Our Case Number: ABP-320946-24

Re: Development at Long Point, Lake Road (R351)
Knockanima, Loughrea, County Galway

RE Long Point Developement
at Knockanina Loughrea

Project: LONG POINT OUTDOOR AMENITY ENHANCEMENT PROJECT
Drawing No: LAYOUT PLAN SHOWING PROPOSED SERVICES.
Client: GALWAY COUNTY COUNCIL

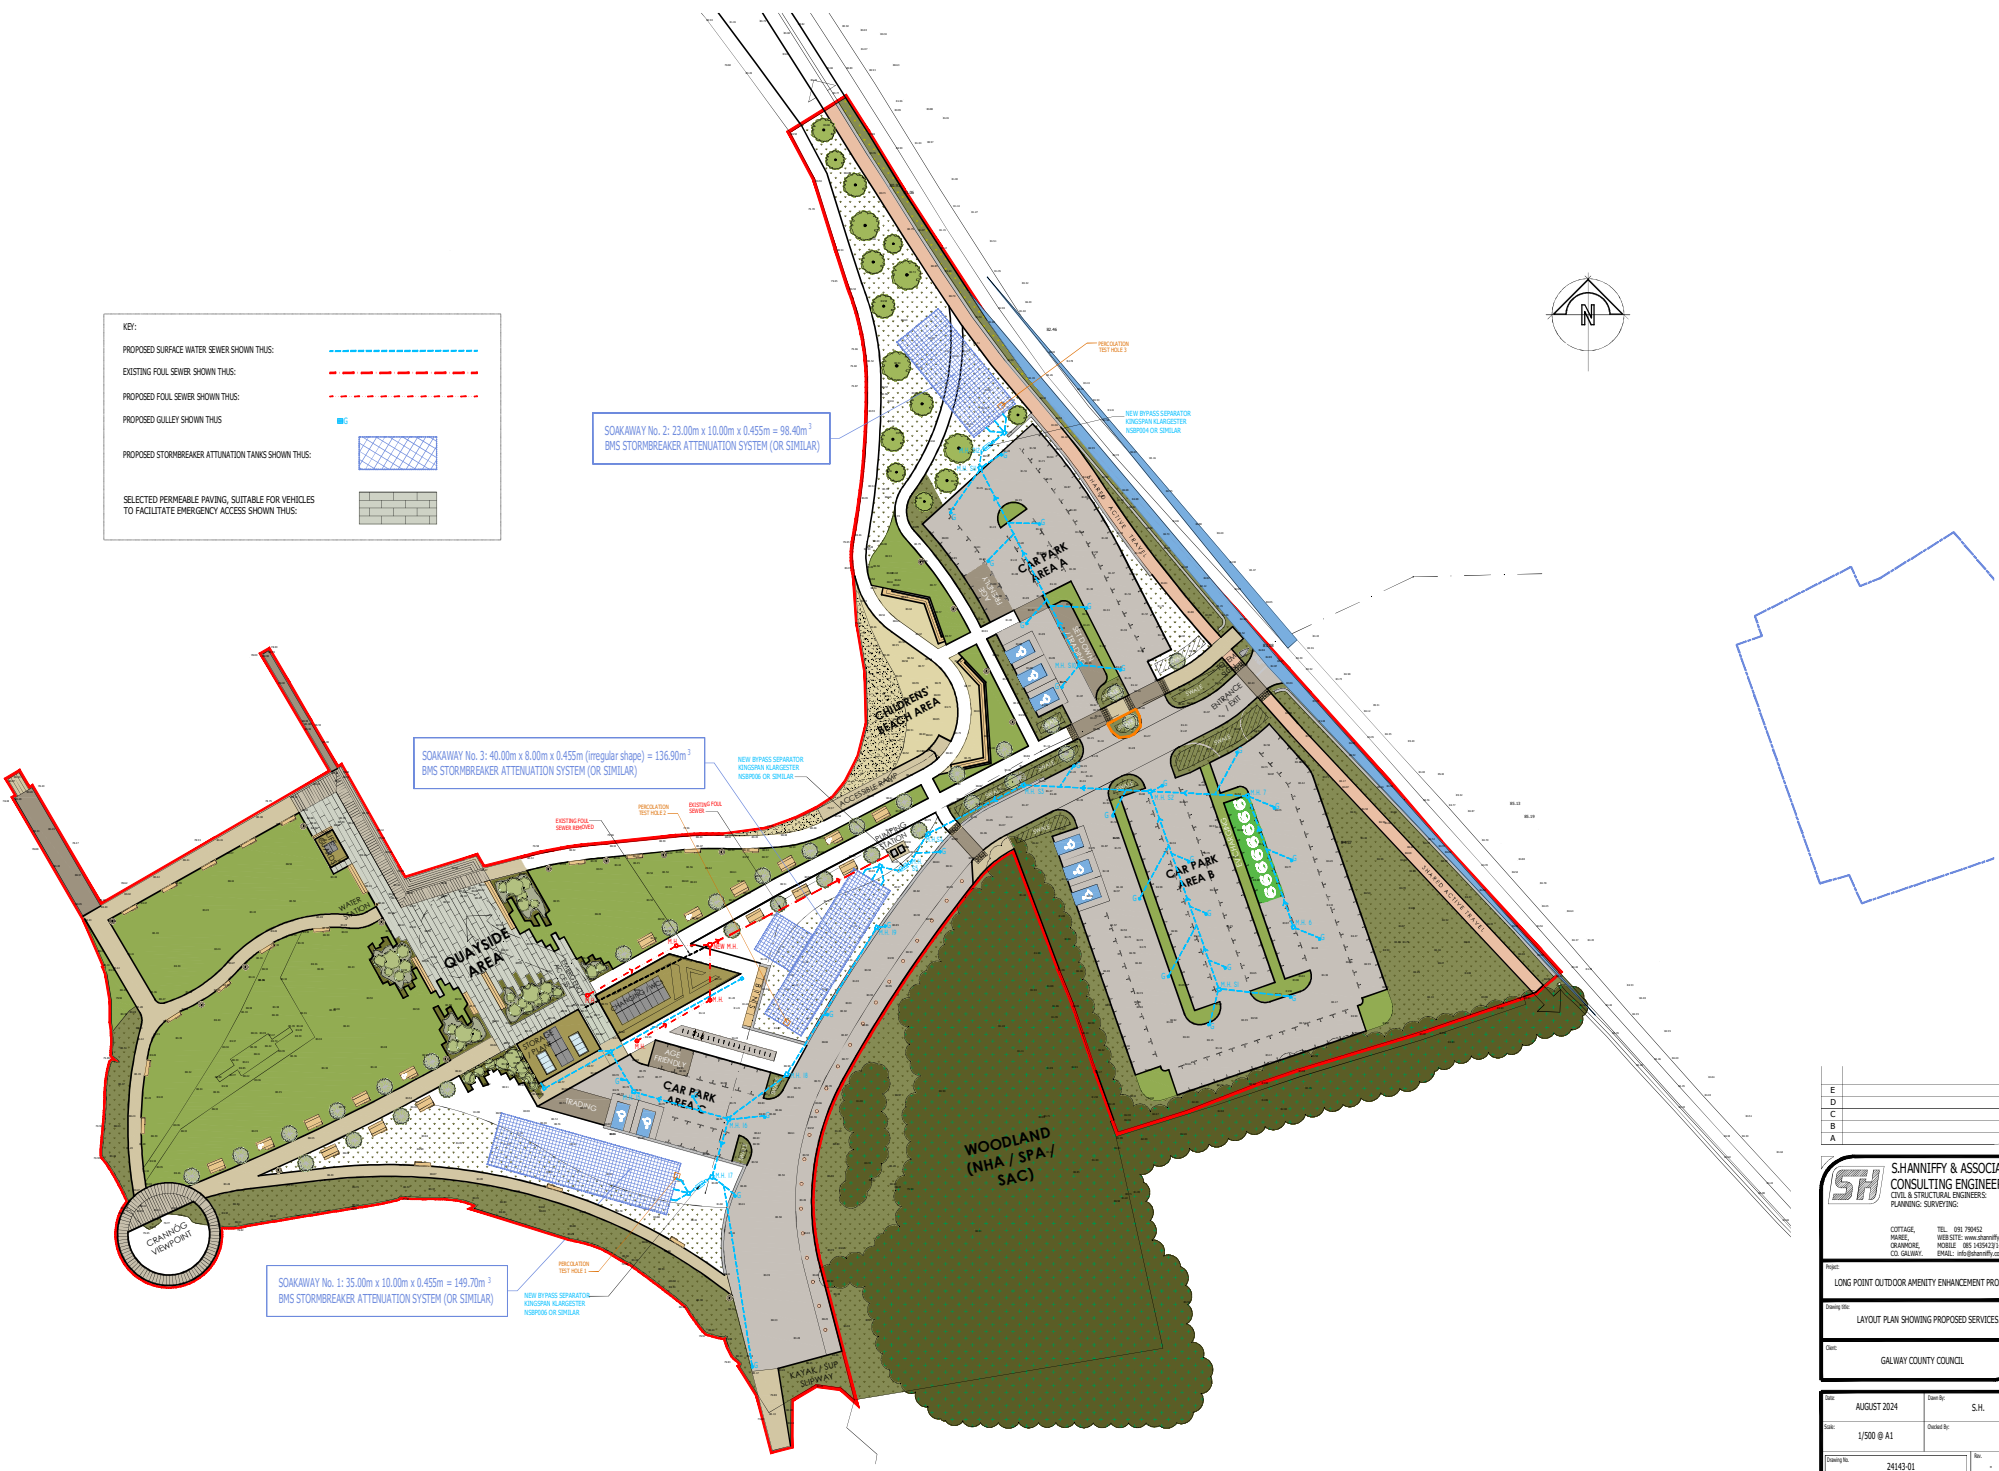
- 1 Existing changing shelter should not be removed:
 - a It is vandal proof.
 - b Provides shelter 24hrs every day.
 - c Does not require maintenance attendance.
 If anything it should be enhanced by the addition of a 1/2m wall to provide weather protection whilst all year swimmers are changing.
- 2 Car Park area C should be curtailed as green area is important for aspect and space for childrens play.
- 3 Childrens ^{beach} area should be left as is.
